SUBMISSION ON HUNTER VALLEY OPERATIONS – ENVIRONMENTAL
IMPACT STATEMENT

HVO NORTH OPEN CUT COAL CONTINUATION PROJECT SSD – 11826681

HVO SOUTH OPEN CUT COAL CONTINUATION PROJECT SSD – 11826621

FEBRUARY 2023

Figure 28 Time series of 24-hour average PM₁₀ at Jerrys Plains (property 308)

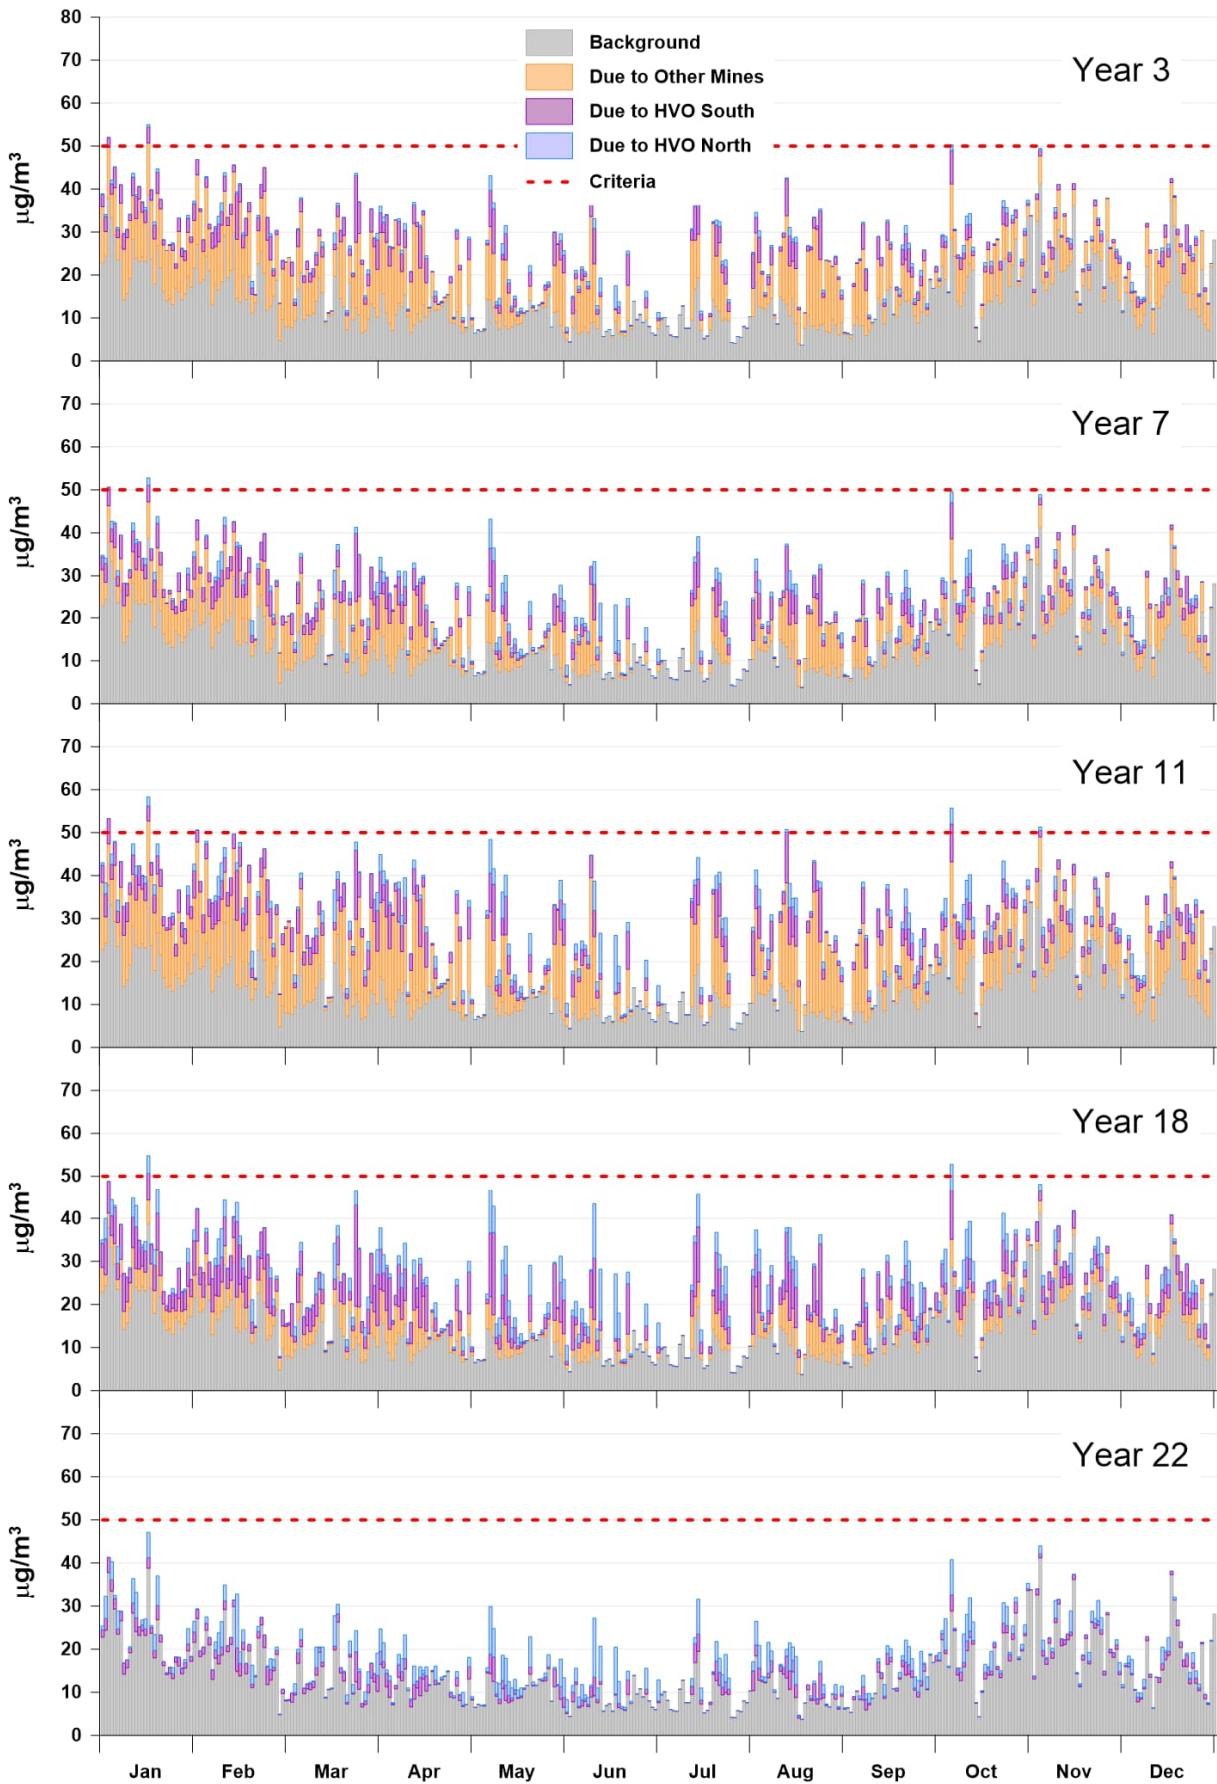
37. The HVO submission identifies receptor 308 as having increased air quality impact risks and has been identified as qualifying for air quality acquisition rights.

38. This receptor is a clear indicator of the potential air quality impacts of the Project on Coolmore (situated only some 3km away from the HVO North operation).
